**Upgrade to North Sydney Public School (SSD-11869481)
Response to Submissions**

ATTACHMENT 1 – KEY ISSUES

SHADOW DIAGRAMS 01

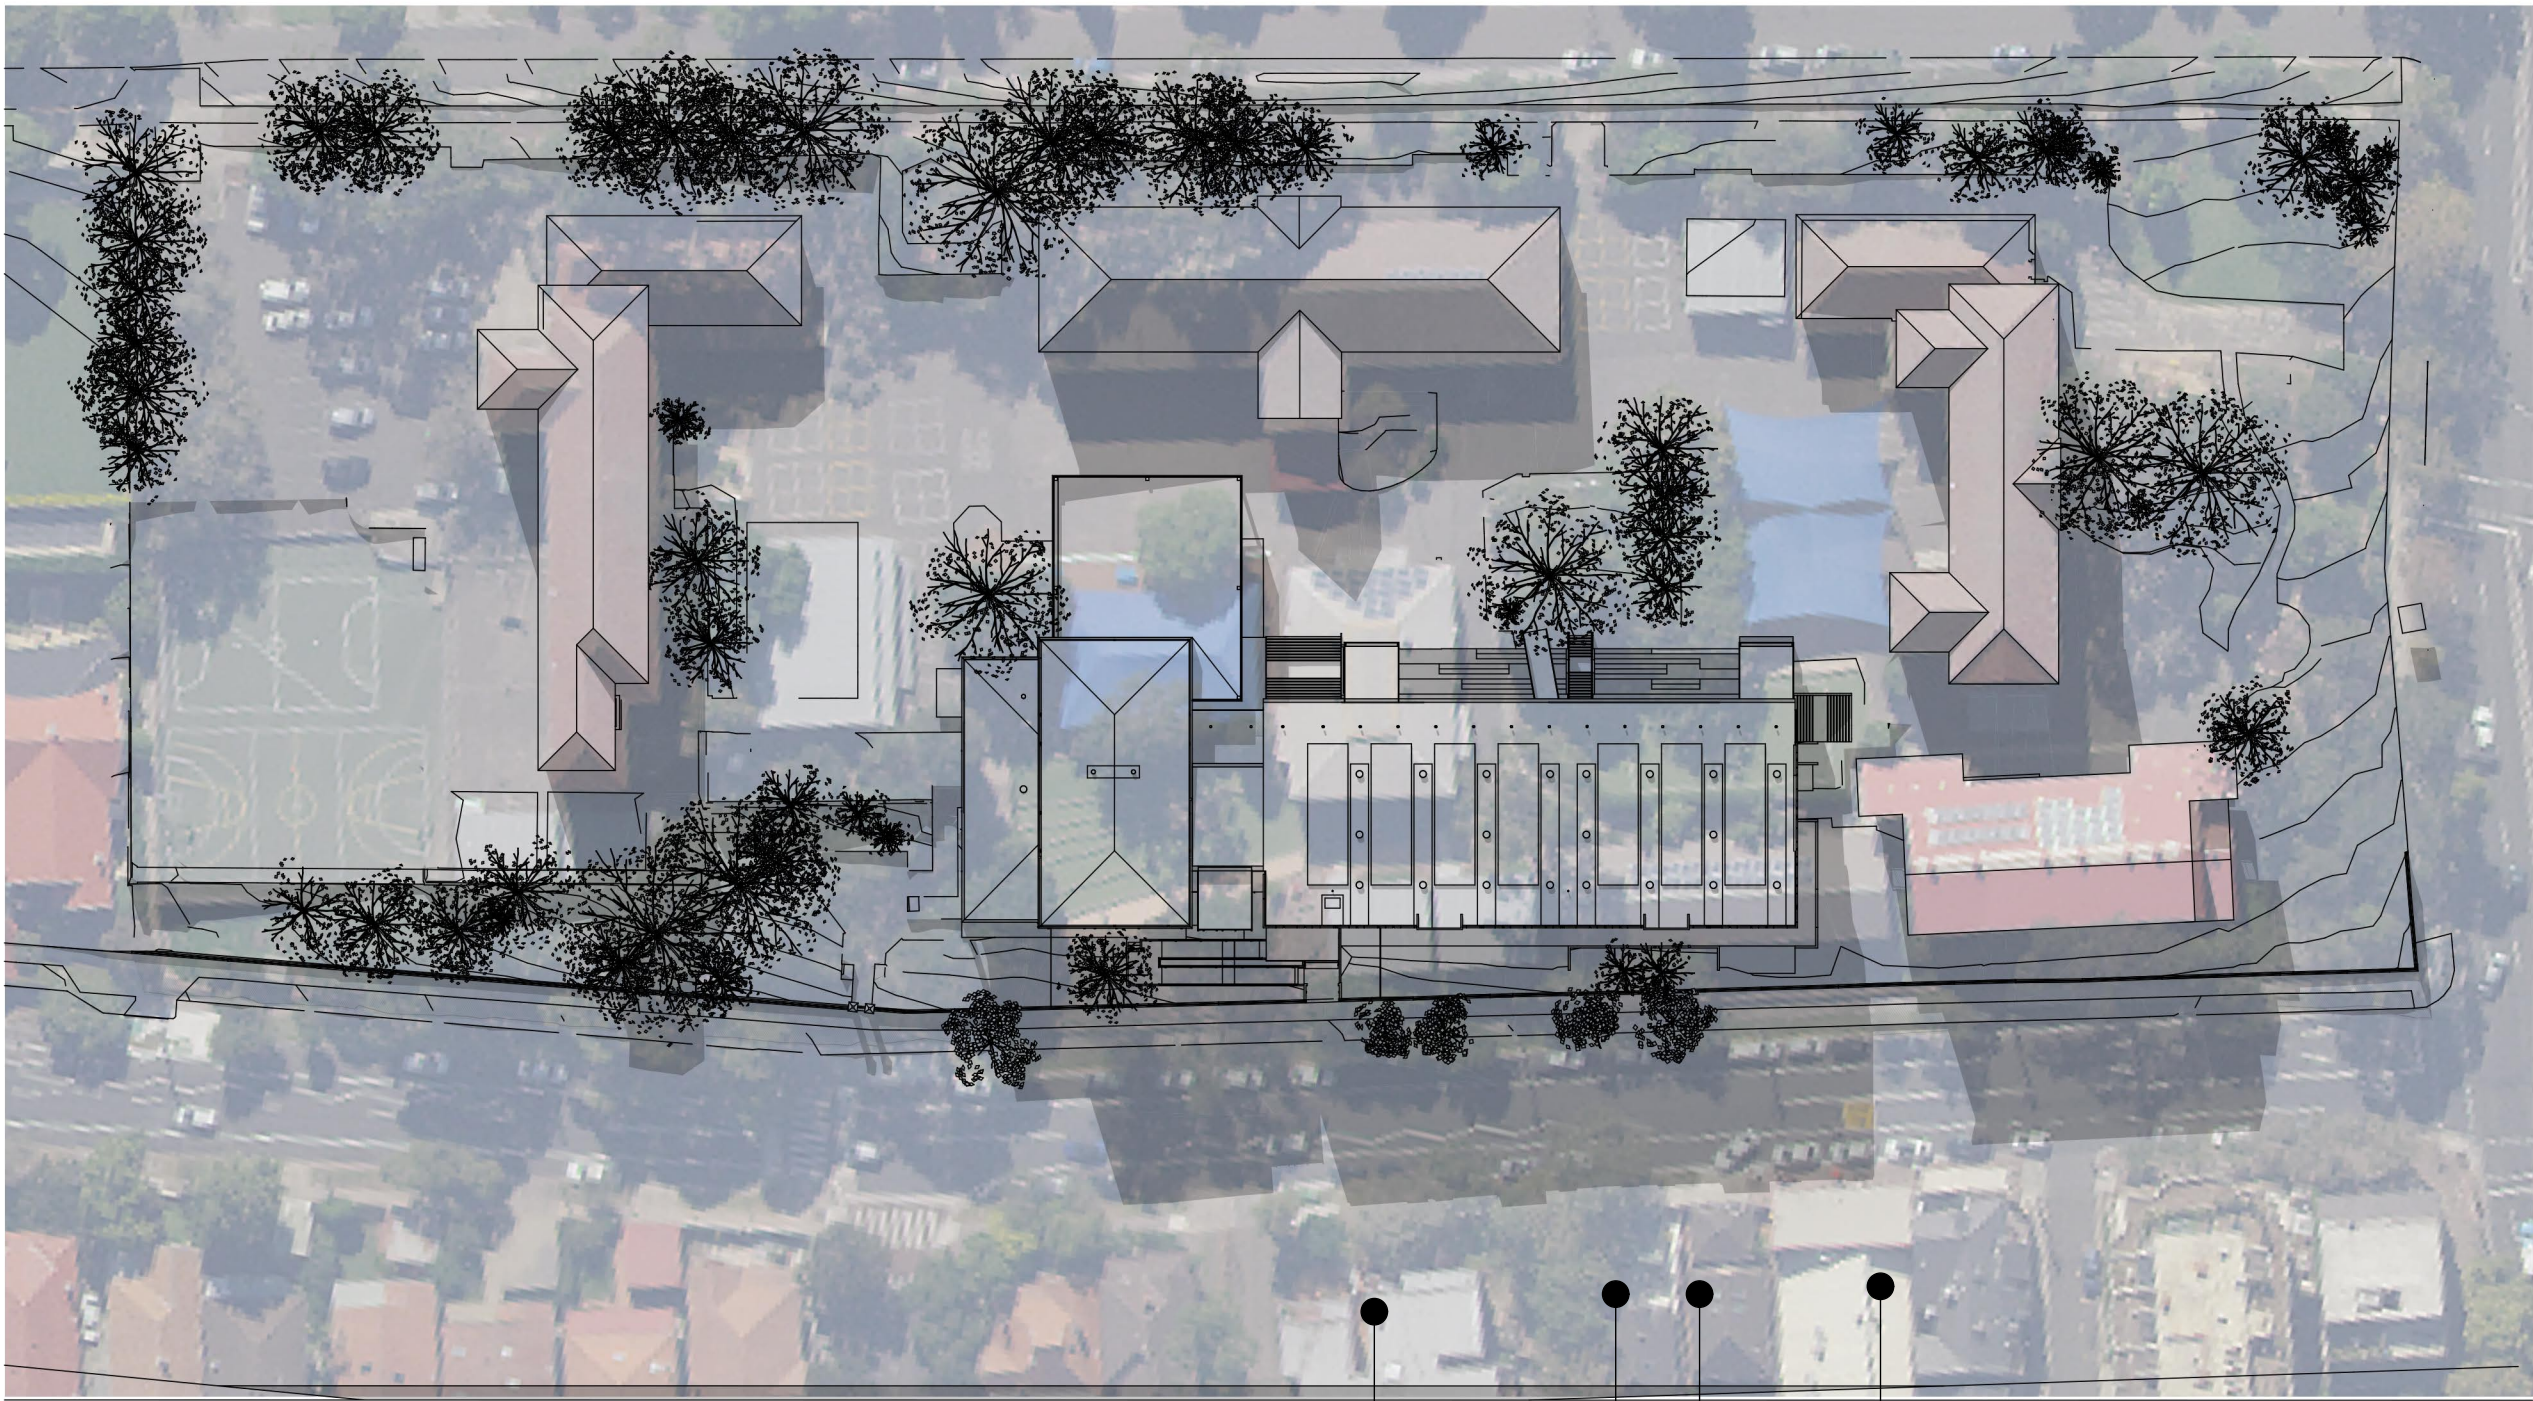
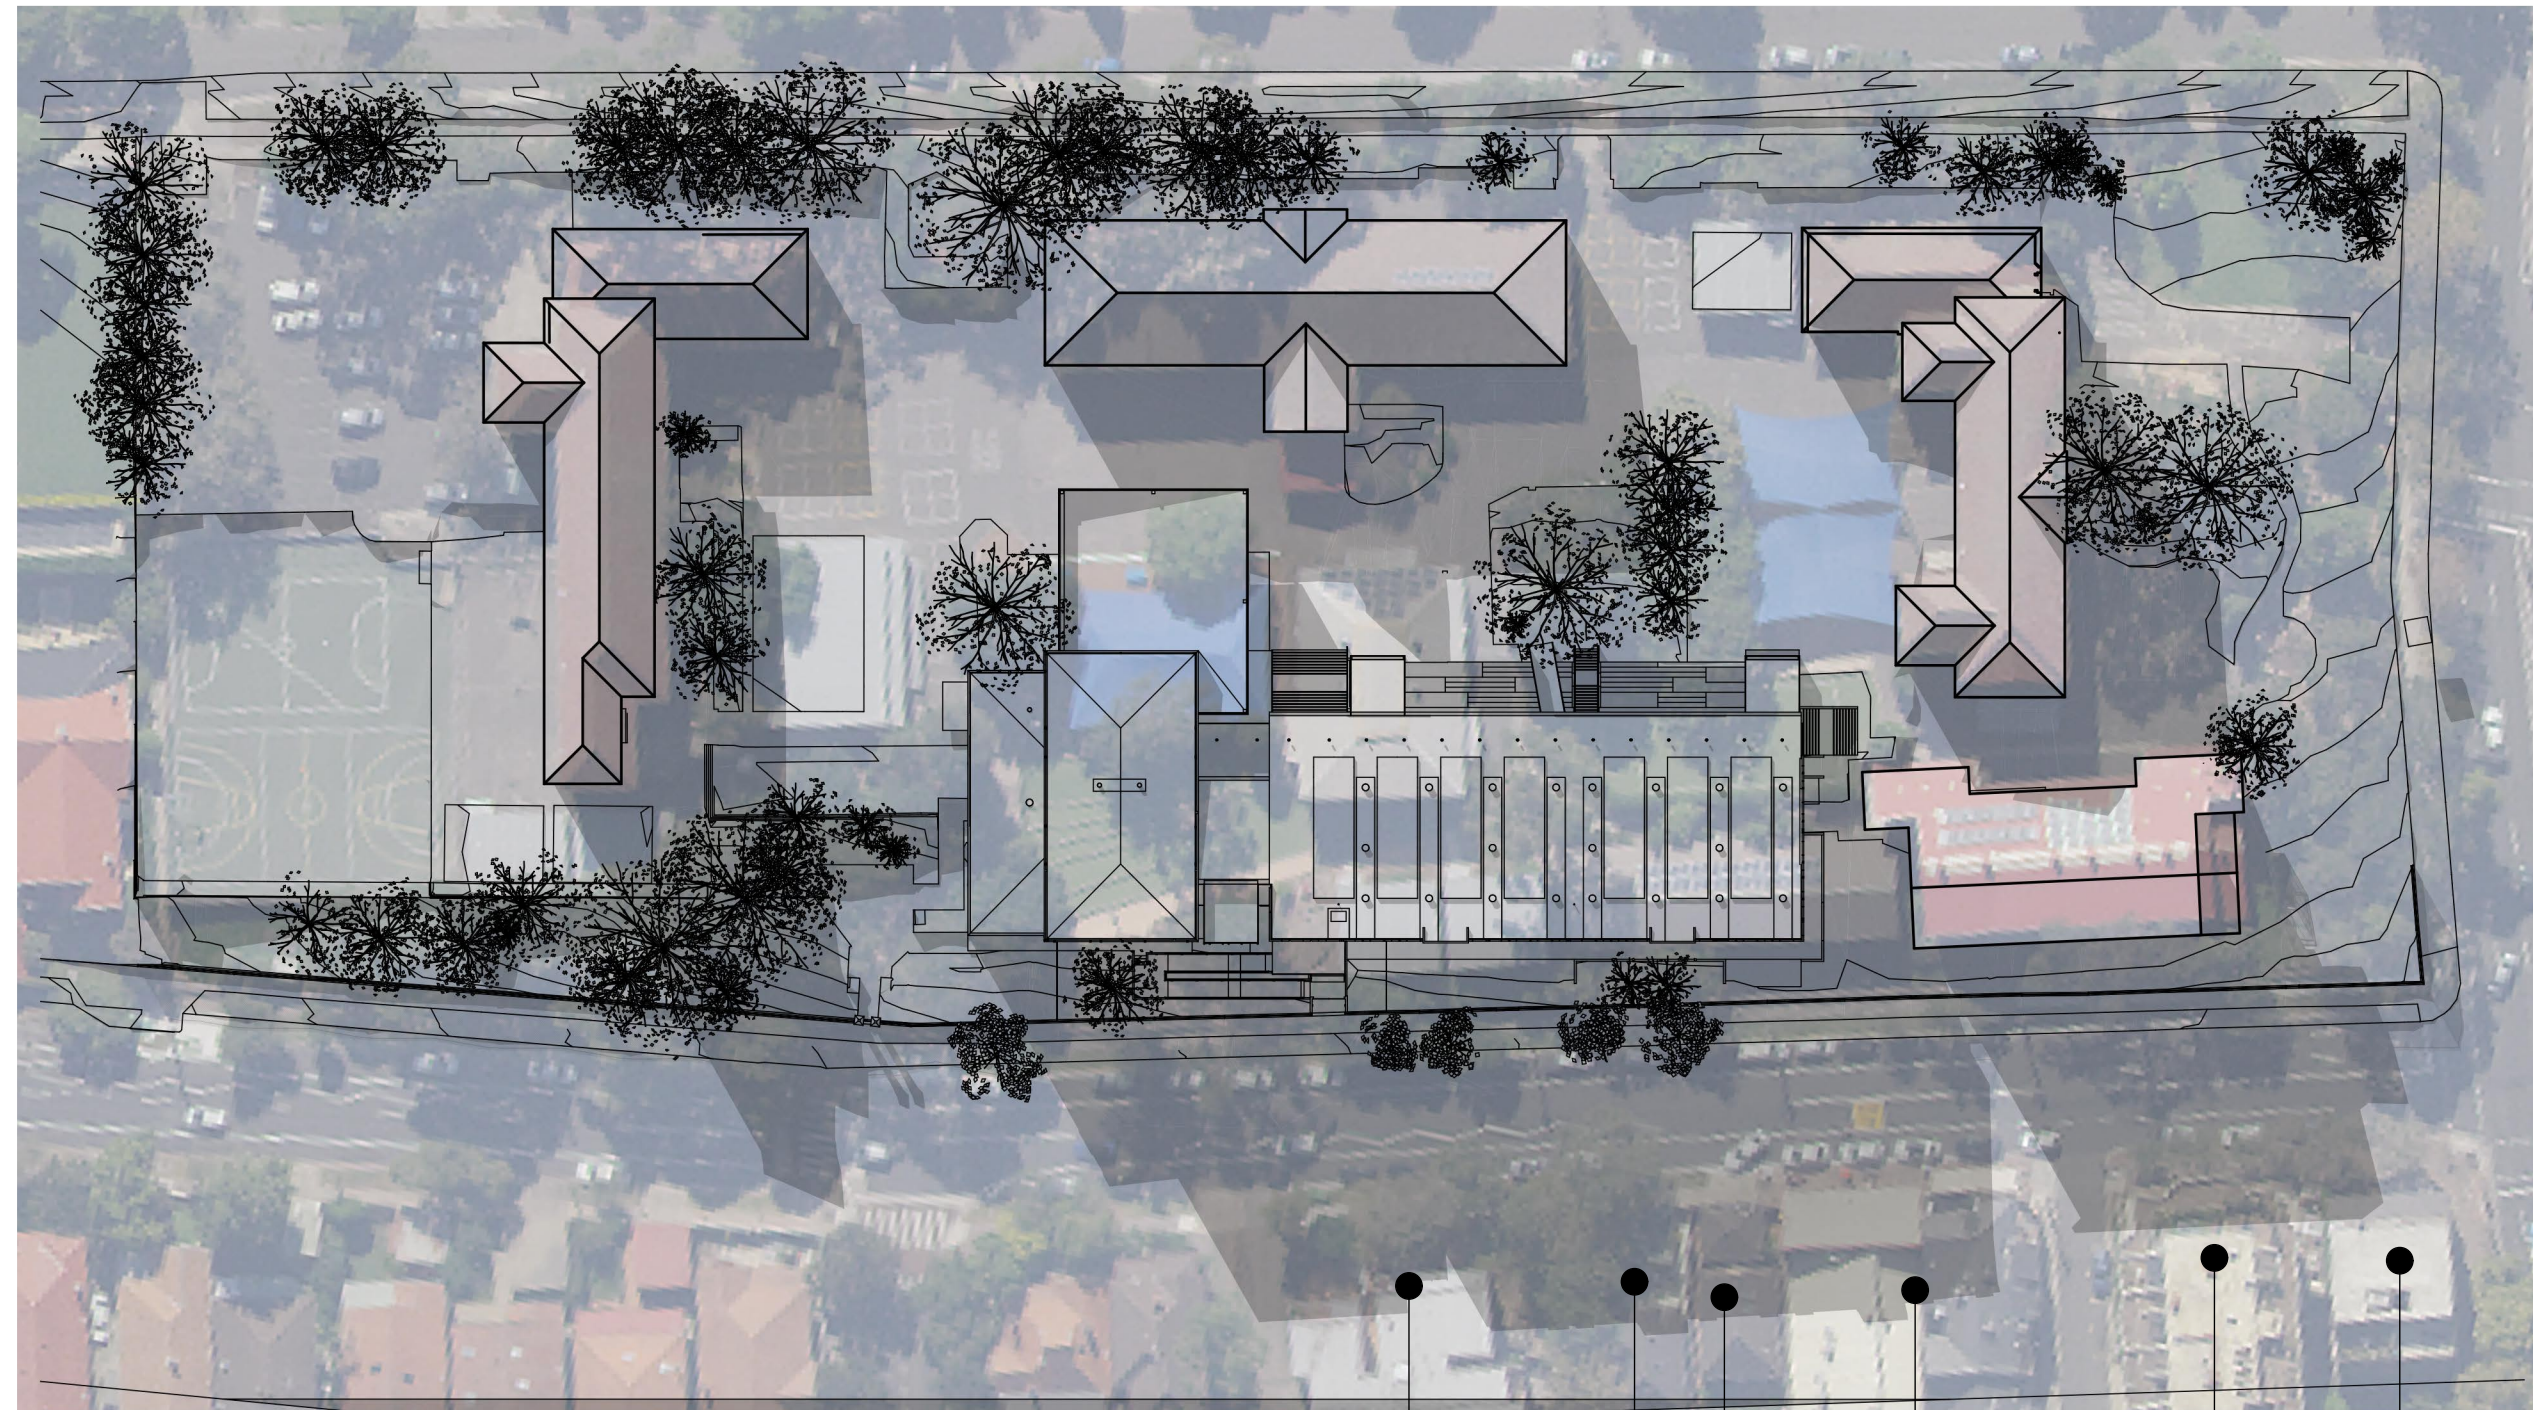
5. Sections 7.3.2 and 7.1.2 of the EIS state that shadows generated by the proposal would not impact surrounding development and that shadows would fall onto Bay Road and the footpath at 3pm in mid-winter. The shadow diagrams lodged with the EIS show that at 3pm shadows are cast across Bay Road and onto properties opposite the site on Bay Road. To allow for proper assessment of shadow impacts, hourly shadow diagrams are required between 12pm and 3pm in mid-winter, and elevation shadow diagrams are required to demonstrate from what time and where shadows will fall on north facing elevations of development opposite the site on Bay Road.

Figure 2: Amended Bay Road entry (Source: Fulton Trotter)

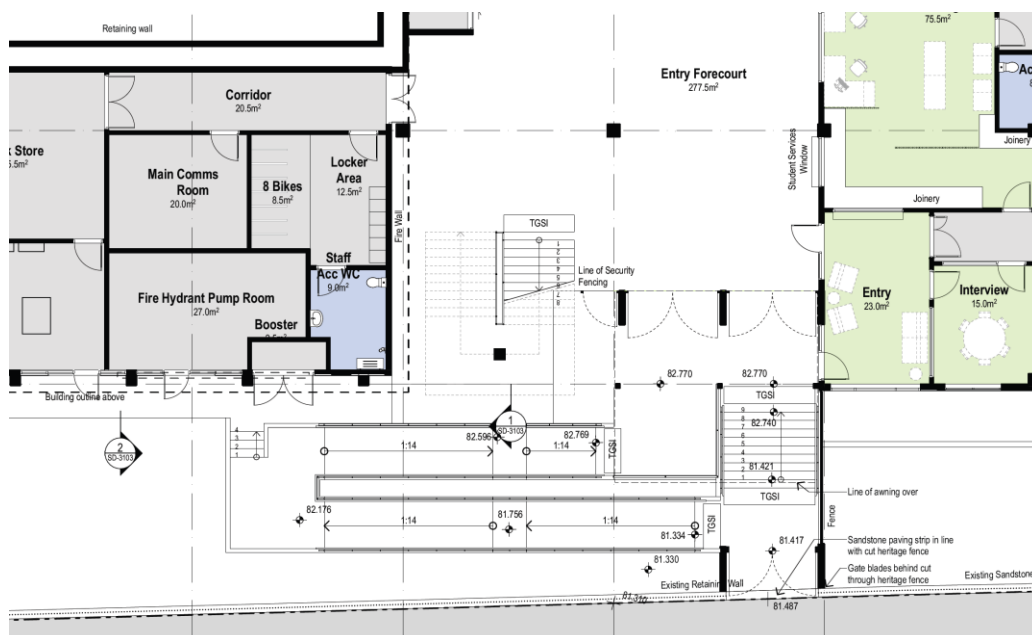
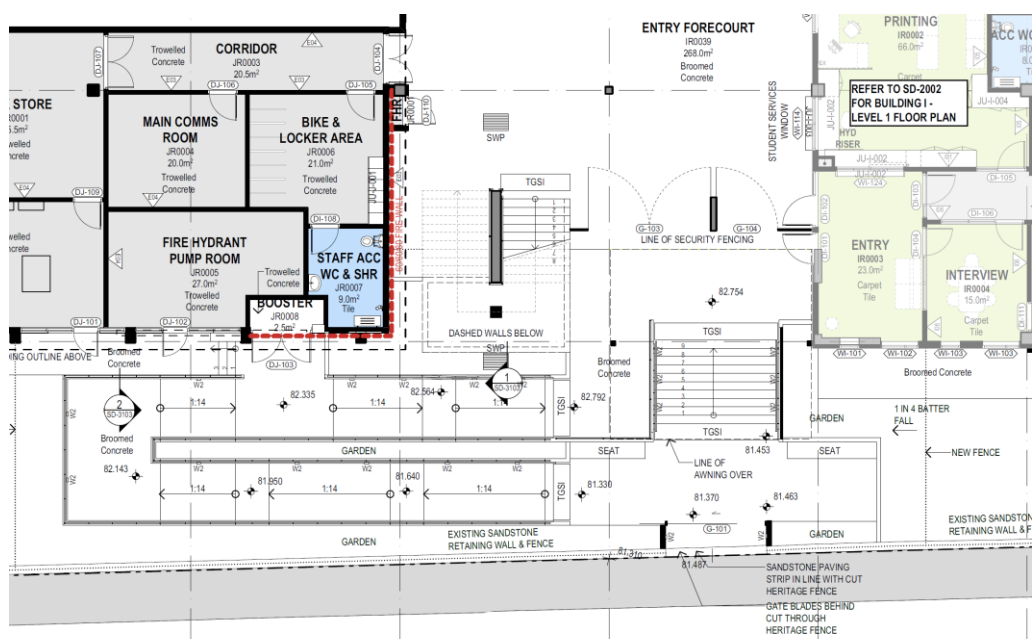
3. Concern is held that:
 - a) the proposed design of the new entry on Bay Road would not provide an open and inviting entry off Bay Road and its ground area and stairs leading into the school would be constrained potentially not accommodating the number of students likely to use the entry. Further, the proposed dimensions of the access ramp appear to be minimal and could result in access issues for pedestrians and strollers.

Figure 14: Extract of amended east elevation of Building I (Source: Fulton Trotter)

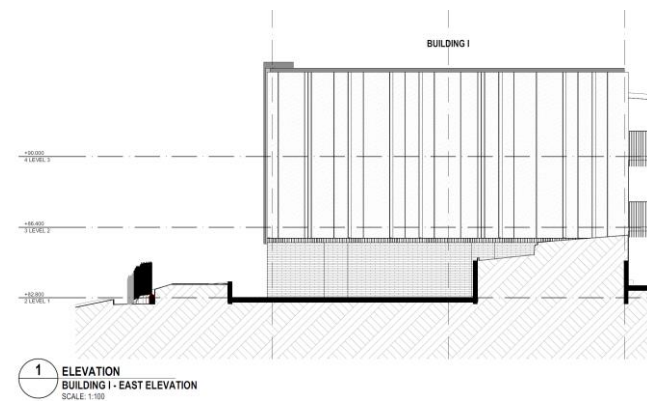
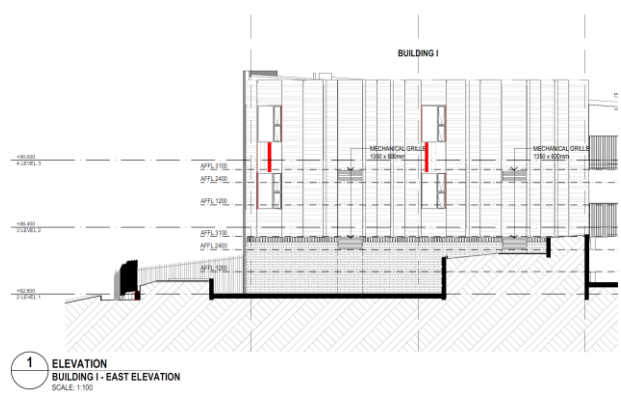
- c) the eastern elevation of Building I proposes full height panels without windows, presenting massing and scale impacts when viewed from Bay Road.
